**WELWYN HATFIELD COUNCIL – DEVELOPMENT CONTROL**  
**DELEGATED REPORT**

<b>APPLICATION No:</b>	<b>S6/2009/1940/FP</b>
------------------------	------------------------

The application seeks full planning permission to extend the front of the dwelling to increase the depth of the existing garage and living room and to create a new front entrance and hallway. At the rear of the dwelling the existing kitchen is to be extended. A new utility room is proposed to the side.

**FLOOR PLANS PROPOSED**

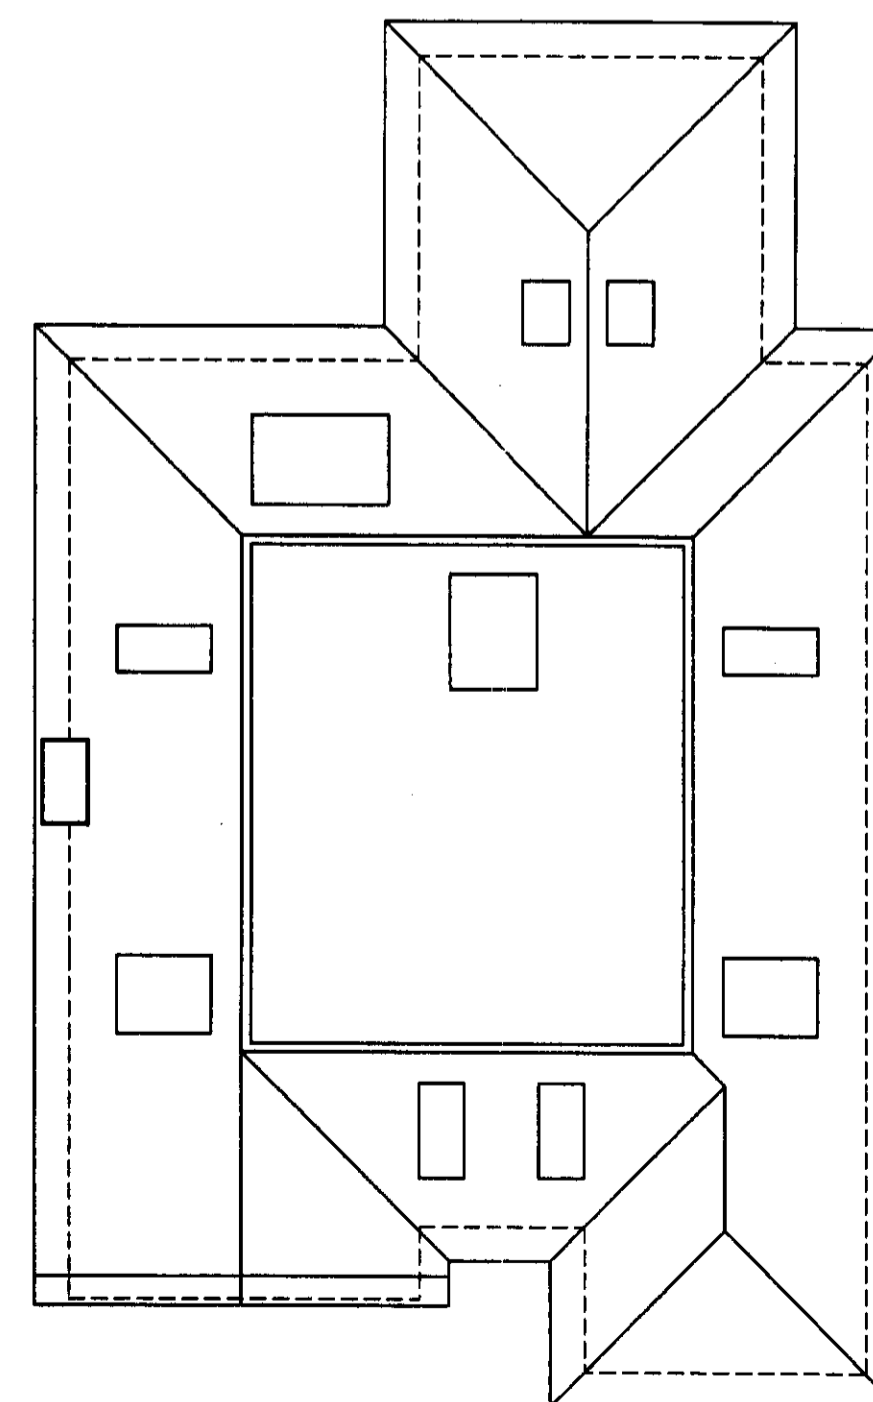
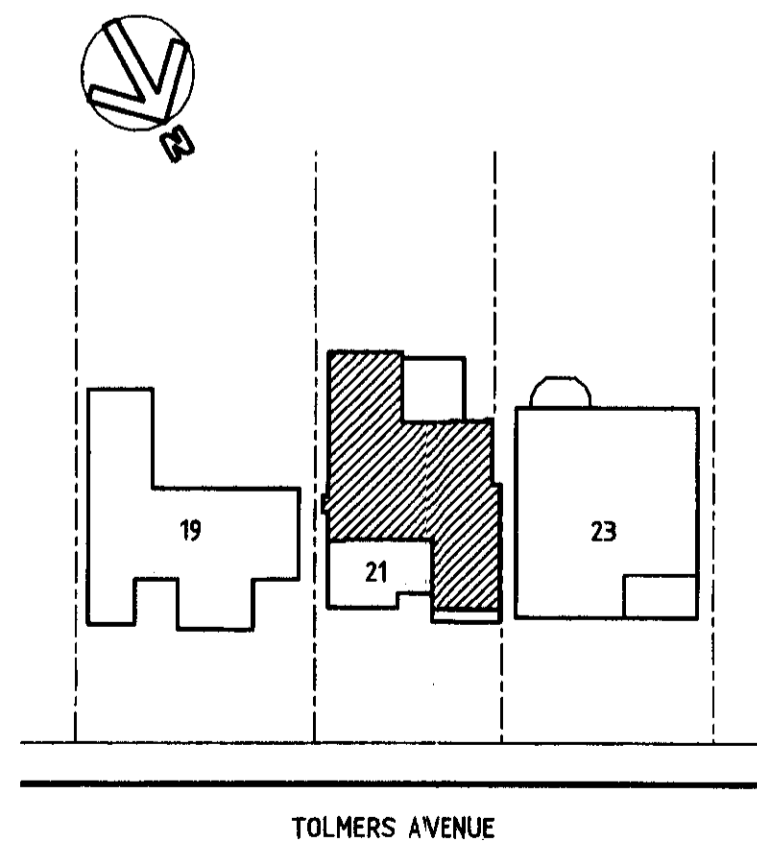
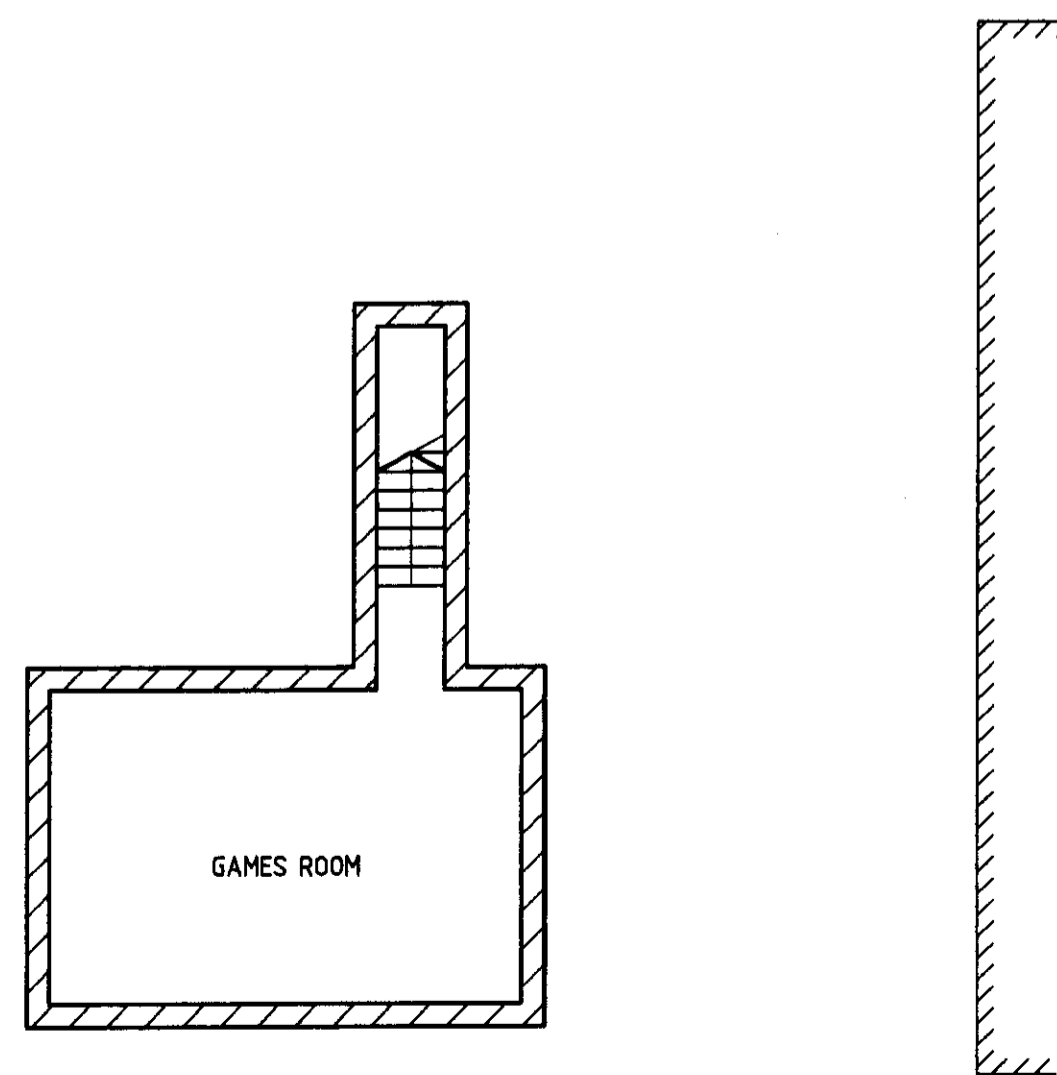
In regards to the proposed two storey rear extension, the amended drawing has reduced the depth of this so that it projects approximately 3.1m beyond the rear wall of No.23. Taking into account the separation distance between the two properties and the proposed hipped roof, it is considered that this would not impact unduly on this neighbouring property in regards to loss of sunlight/daylight. The depth of this proposed extension is also not considered to appear either over-dominant or overbearing when viewed from this neighbours property.

In regards to No.23, the front extension has been stepped back from this neighbours main forward gable, which reduces the impact on their existing front windows. This is considered sufficient to ensure that no unacceptable loss of daylight/sunlight will result to their windows. Side windows are proposed for the lounge and bedroom above which can be subject to a planning condition that they are obscure glazed.

The proposed side rooflights to the second floor for bedroom 5 are considered to be in a location which would not result in any undue loss of privacy to neighbours. The rooflights to the storage area and bedroom 6 and bathroom should however be

Policy M14 and the Supplementary Planning Guidance is relevant. The dwelling is located in Zone 4 where a maximum of three spaces are required for the number of bedrooms proposed. Two parking spaces are proposed in front of the single garage. The width of the driveway is approximately 4.5m and so a planning condition requiring this to be a minimum of 4.8m is reasonable.

5. The side windows shown on the approved drawings to bedroom 2 and lounge room, and the second floor rooflights to the storage area, bathroom and bedroom 6 of the proposed building shall be glazed with obscured glass and shall be fixed so as to be incapable of being opened below a height of 1.7 metres above floor level, and shall be retained in that form thereafter.

6. Notwithstanding the details shown on approved drawing 02 Rev D, the width of the driveway is to be a minimum of 4.8 metres.

TITLE Solarglaze Fixed  
 150mm Kerb

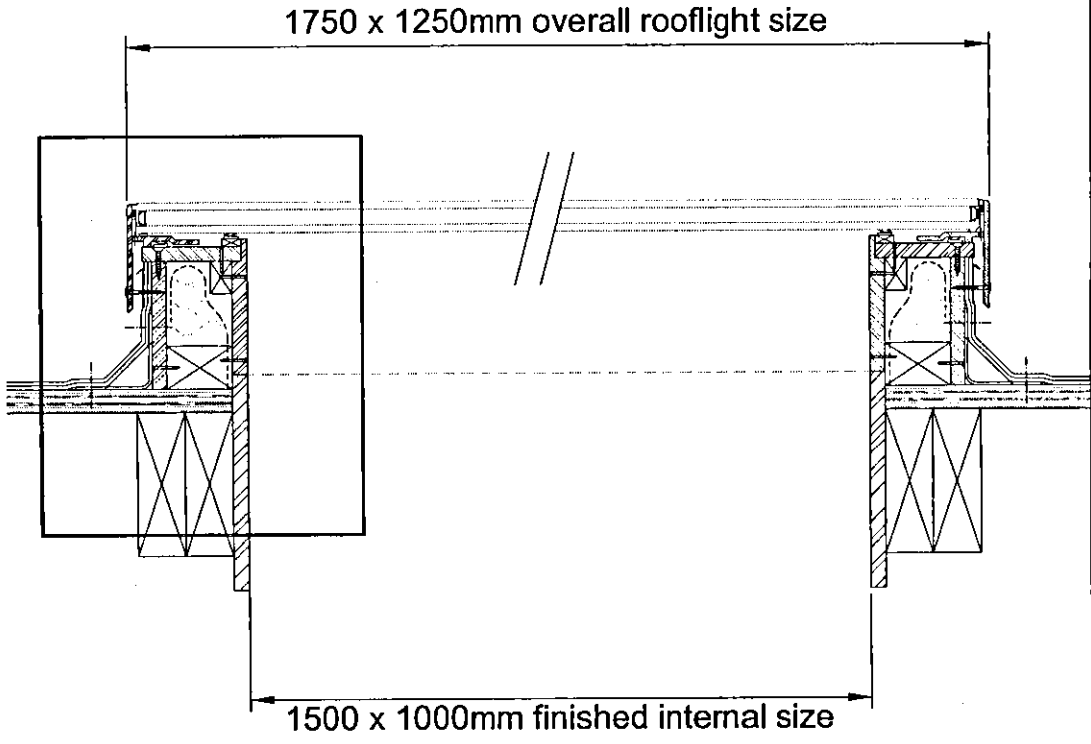
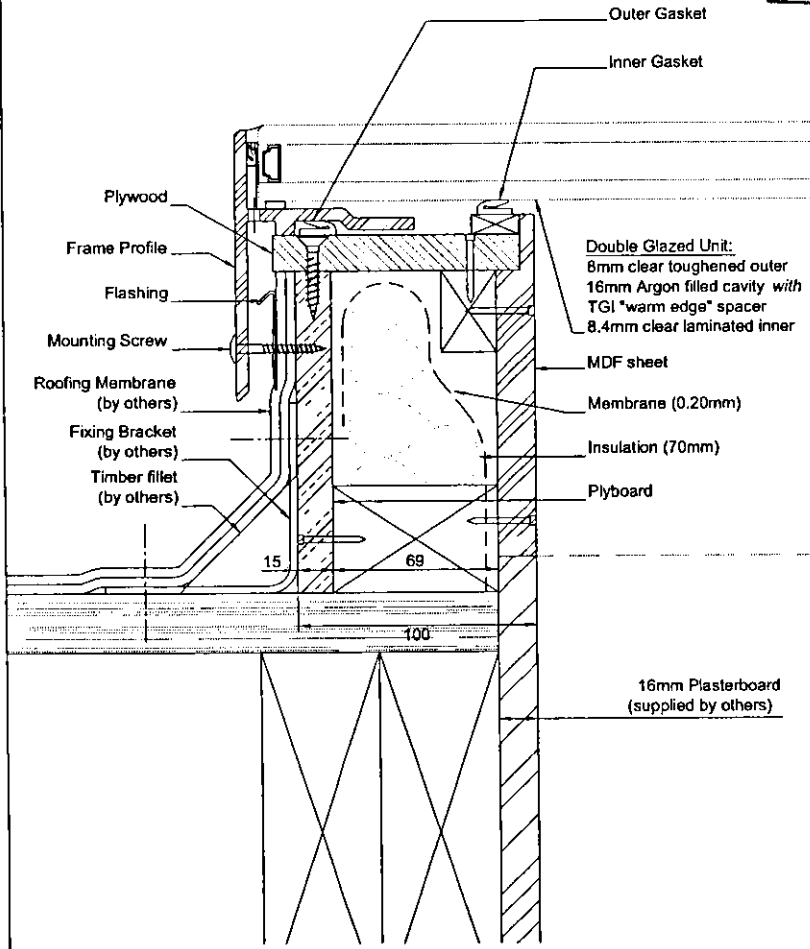
A rooflight is proposed on the new crown roof. Details of this have been submitted, and it is considered that this is of a height and location that will not be visible from the highway and so is considered to be acceptable.

1. C.2.1 3 Year time limit.
2. C.13.1: Development in accordance with approved plans/details 1:1250 Site Location Plan received and dated 17 SEP 2009 & 02 Rev D & 03 Rev D & Solarglaze fixed 150mm Kerb rooflight details received and dated 5/11/09
3. C.5.1 Materials to be approved.
4. The rooflight shown on the submitted drawing titled 'Solarglaze Fixed 150mm Kerb' is the approved rooflight for the new crown roof.

STREET SCENE  
 AND ELEVATIONS  
 PROPOSED

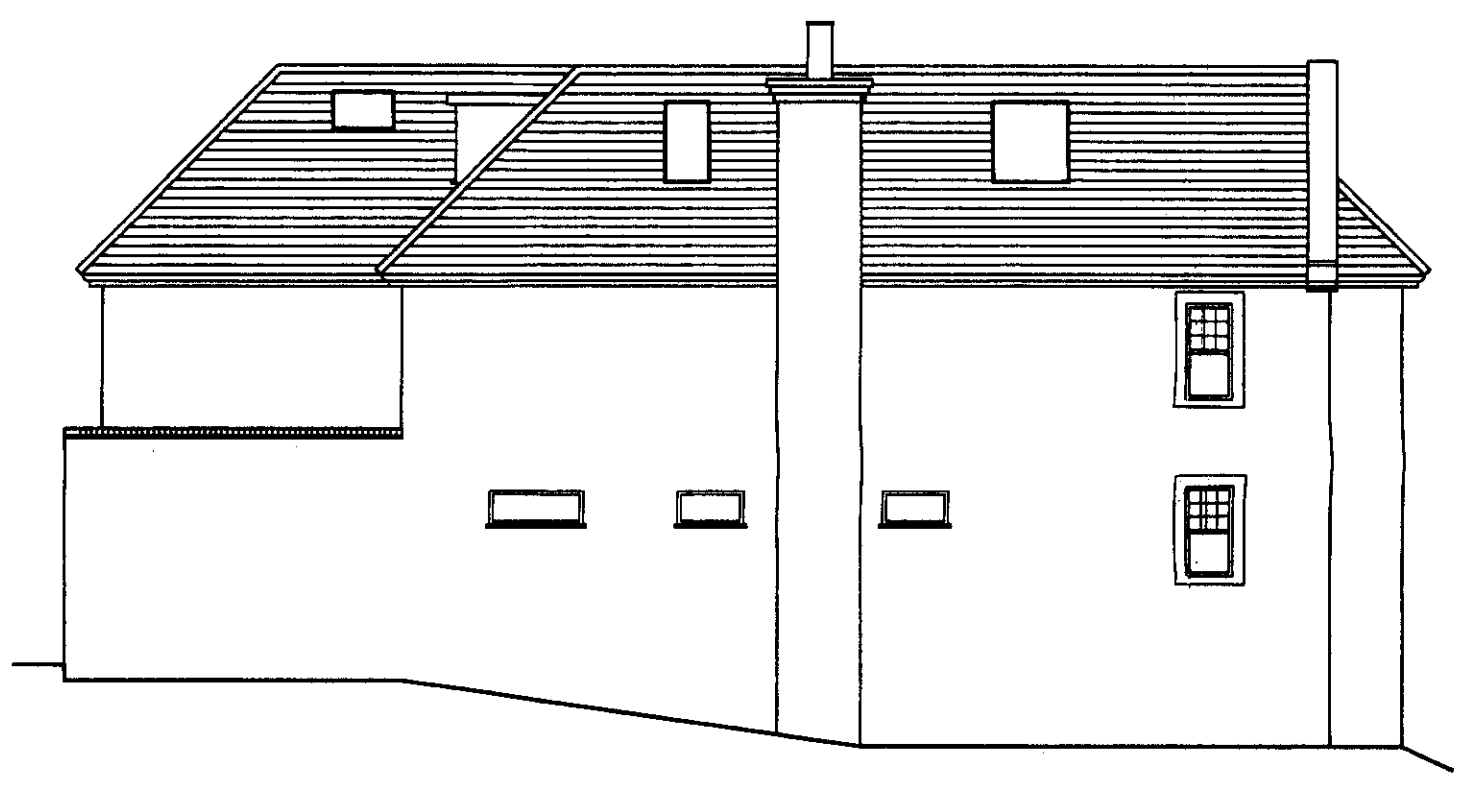
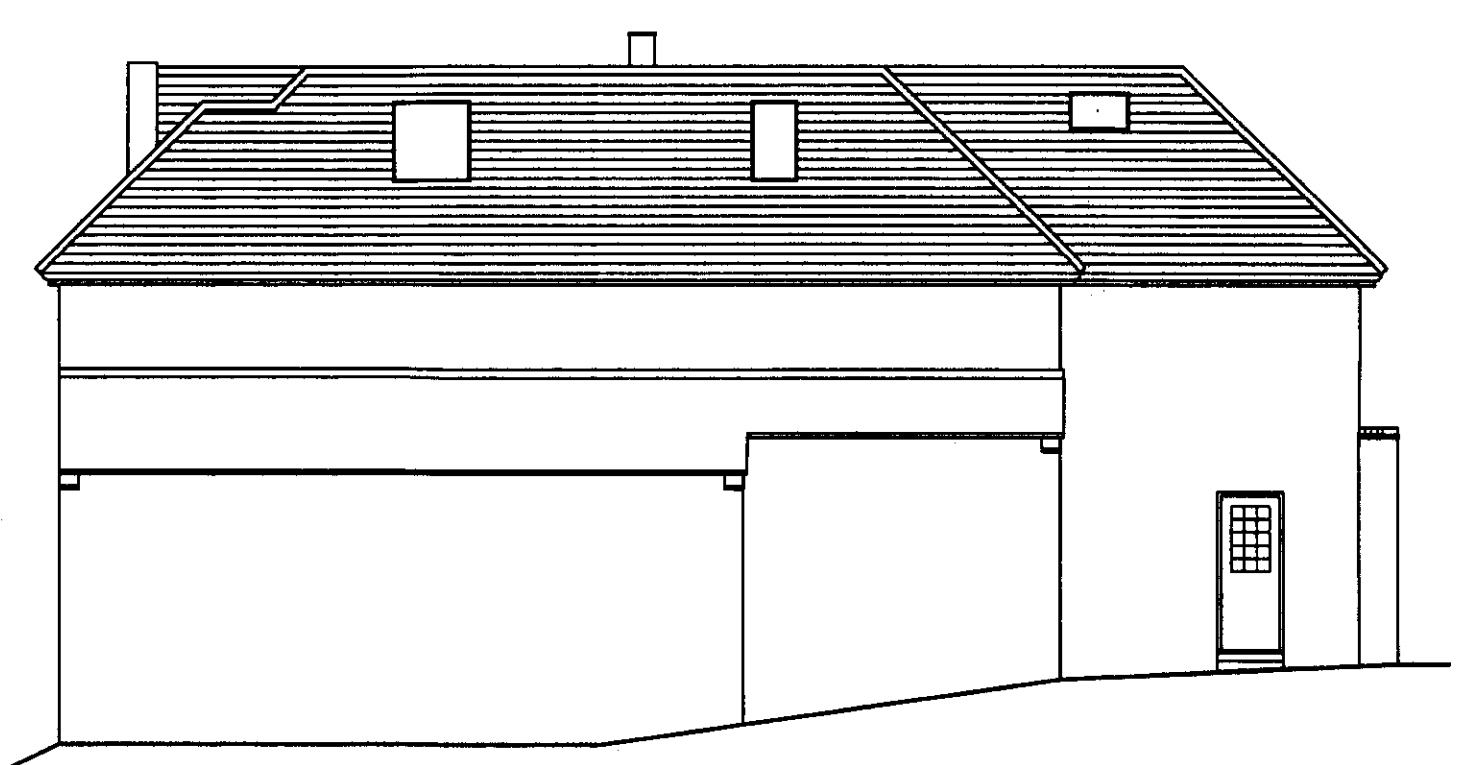
Amended drawings have also been received during the application process which has made some further minor design changes to the front elevation by changing over the new gable to the left side of the dwelling and removing the window to the basement.

The proposed new ridge height is indicated to be 20.800 compared to 20.020 at No. 21 and 20.450 at No.23. This means the new roof will be higher than the adjoining dwellings, however, the road level increases when travelling southwards and the heights survey drawing shows that the ridge heights of the dwellings step upwards. The increase in height compared to No.21 is therefore not considered to be an issue.

In regards to No.23, this ridge height will be approximately 350mm lower than the proposed new ridge to the application property. Such a relationship also exists between other properties opposite the application site and so the character of the streetscene is not a regular step increase in roof height. Taking this into account, it is considered that the applicant has demonstrated sufficient evidence to show that this increase in ridge height would not be out of keeping with the character of the streetscene.
